EPA Comments on Amended Environmental Impact Statement Documents

Thank you for the referral to the Environmental Protection Authority (EPA) requesting comment on the amended Environmental Impact Statement (EIS) Documents for State Significant Development (SSD) application no.SSD-11606719.

The EIS has been prepared by Arcadis Australia Pacific Pty Limited on behalf of Dial-A-Dump Pty Ltd (the Proponent) for the proposed Eastern Creek Recycling Ecology Park Throughput Increase at Lot 1 DP 1145808, Lot 2 DP 1247691, and part Lot 2 DP 1145808, also known as 1 Kangaroo Avenue, Eastern Creek, NSW, 2766 (the Premises).

**Figure 8-1** Change in days greater than 50µg/m³ relative to background – C18 and R38 – continual application of theoretical peak day emissions

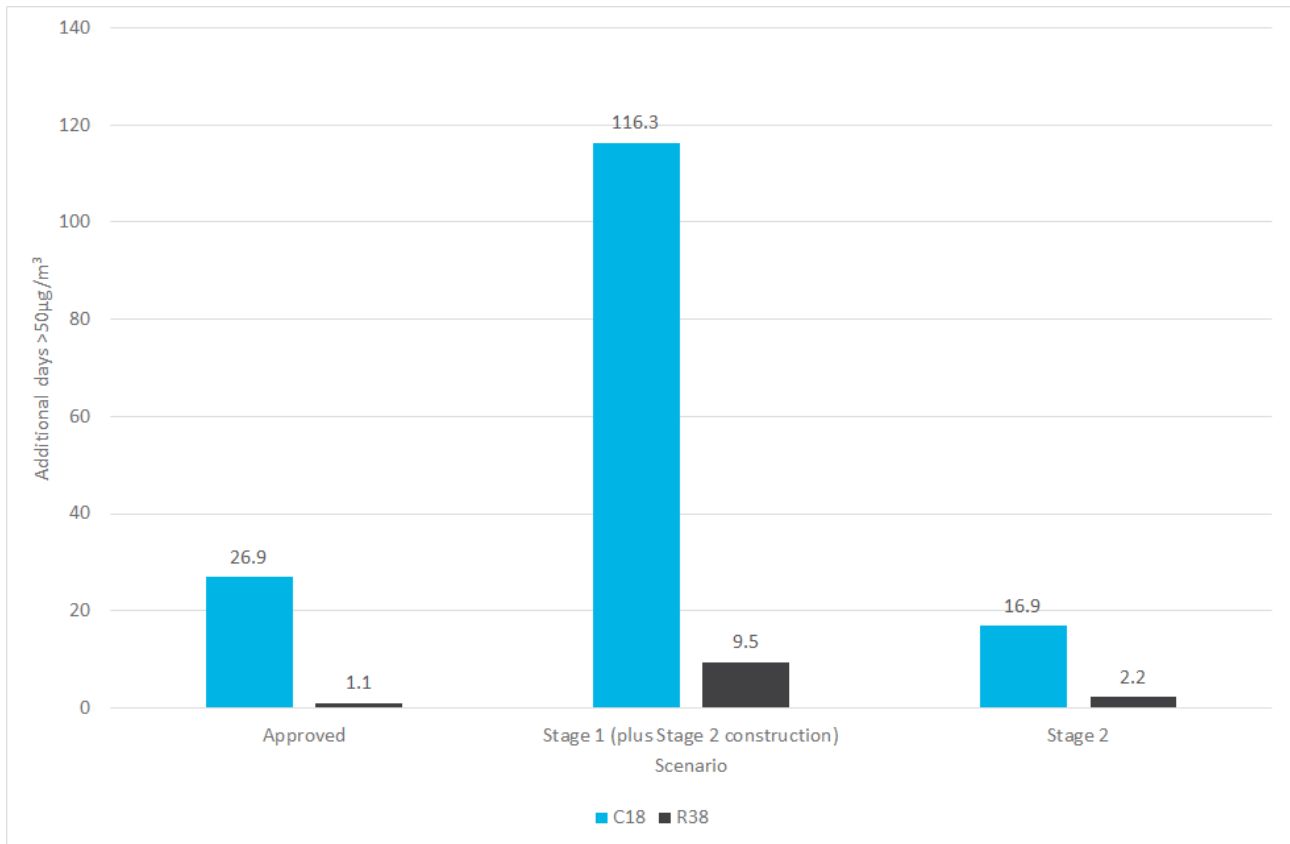
Based on the analysis in Section 8.8 for ‘*Stage 2 operations theoretical busy day*’, the following should be noted:

- (a) it can be concluded that there are predicted additional exceedances of the 24-hr PM₁₀ criteria at residential receptor R31 and commercial receptor CL 18.

- (b) The additional exceedances are predicted for both the 95th percentile (i.e., 1.3 times higher than average throughput) and 100th percentile (i.e., 1.6 times higher than average throughput) sensitivity scenarios.

- (c) The analysis of results at other receptors could likely show that there are additional exceedances at other locations.
- (d) It is reasonable to assume that undertaking a similar analysis for other modelling scenarios (i.e., *Stage 1 + Construction operations theoretical busy day*) will also show that there are additional exceedances predicted at these receptors.

- (e) The analysis of results for the *theoretical busy day* does not include results for 24-hr PM_{2.5}. Therefore, additional analysis must be provided to robustly demonstrate that the proposal will not result in exceedances of the corresponding criteria.

Whilst the probability of exceedances to occur at individual receptors is included in Section 8.8, it is reiterated that this approach is not in accordance with the Approved Methods. Further, the methodology to estimate the probability of exceedances to occur at individual receptors, assumes that the probability of an exceedance to occur in the modelling period and the probability of busy day to occur during the modelling period are two independent events. However, this is not the case. Therefore, there is uncertainty regarding any conclusions drawn from the estimated probabilities.

The proponent nominates the maximum proposed daily:

- (a) Receipt rates.
- (b) Truck movements (in and out).
- (c) Material handling / processing rates.

The dispersion modelling scenarios and assessment be revised to:

- (a) Demonstrate they are representative of reasonable worst-case emissions representative of maximum daily operations as per item (a) above.
- (b) Include additional mitigation measures to ensure no additional exceedances of the impact assessment criteria of all relevant pollutants using a contemporaneous approach as per the Approved Methods for the Modelling and Assessment of Air Pollutants in NSW.

**Figure 8-2** Change in days greater than 50µg/m³ relative to background – C18 and R38 – adjusted for frequency of occurrence (95<sup>th</sup> percentile activity rates)

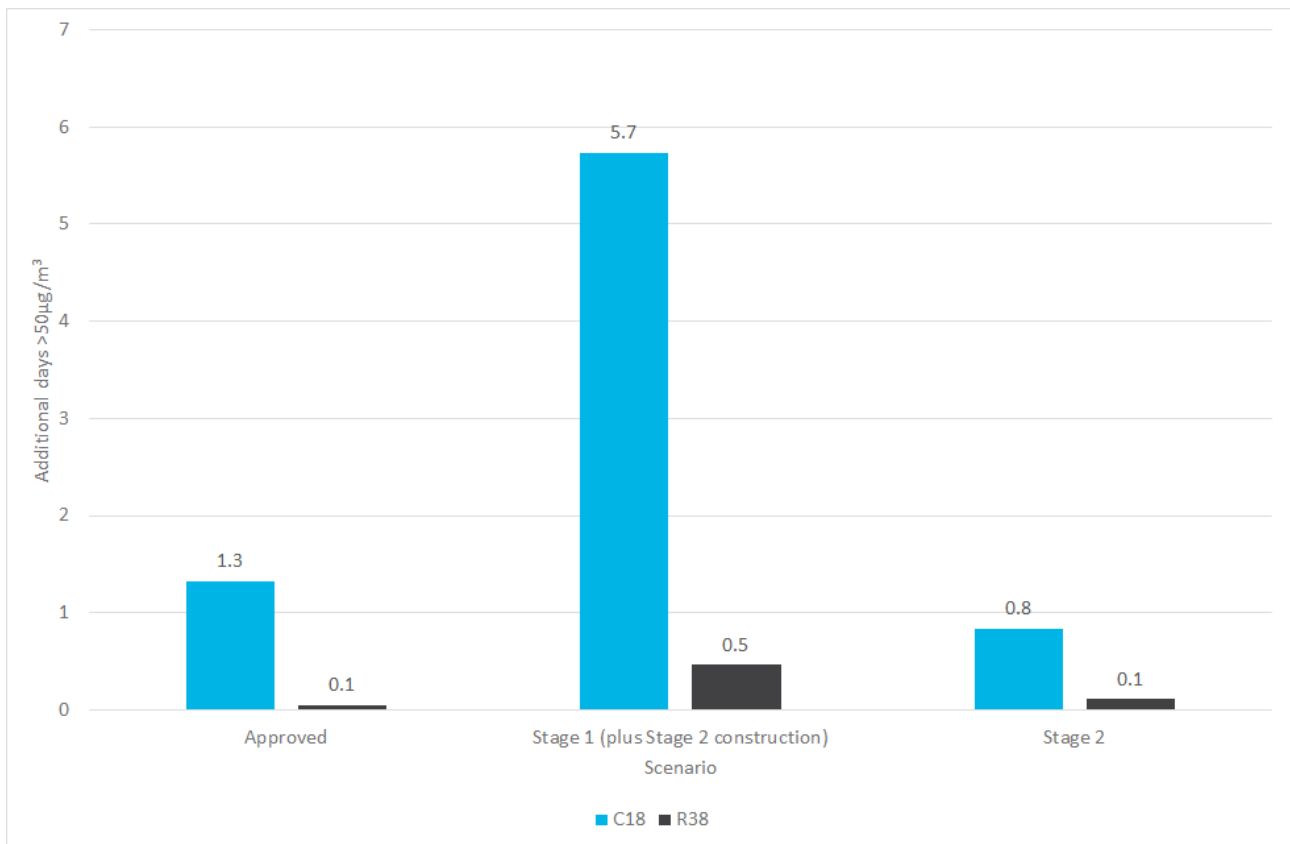
It should also be noted that the analysis of results for the theoretical busy day shows the ‘sensitivity’ of the results and conclusions to changes in the input data and assumptions. For instance, it clearly shows that changes to the maximum daily throughput input data (i.e., number of truck movements and material handling rates) increases the likelihood of additional exceedances to be predicted. Therefore, highlighting the importance of the proponent to nominate the maximum daily throughput receipt and material handling rates.
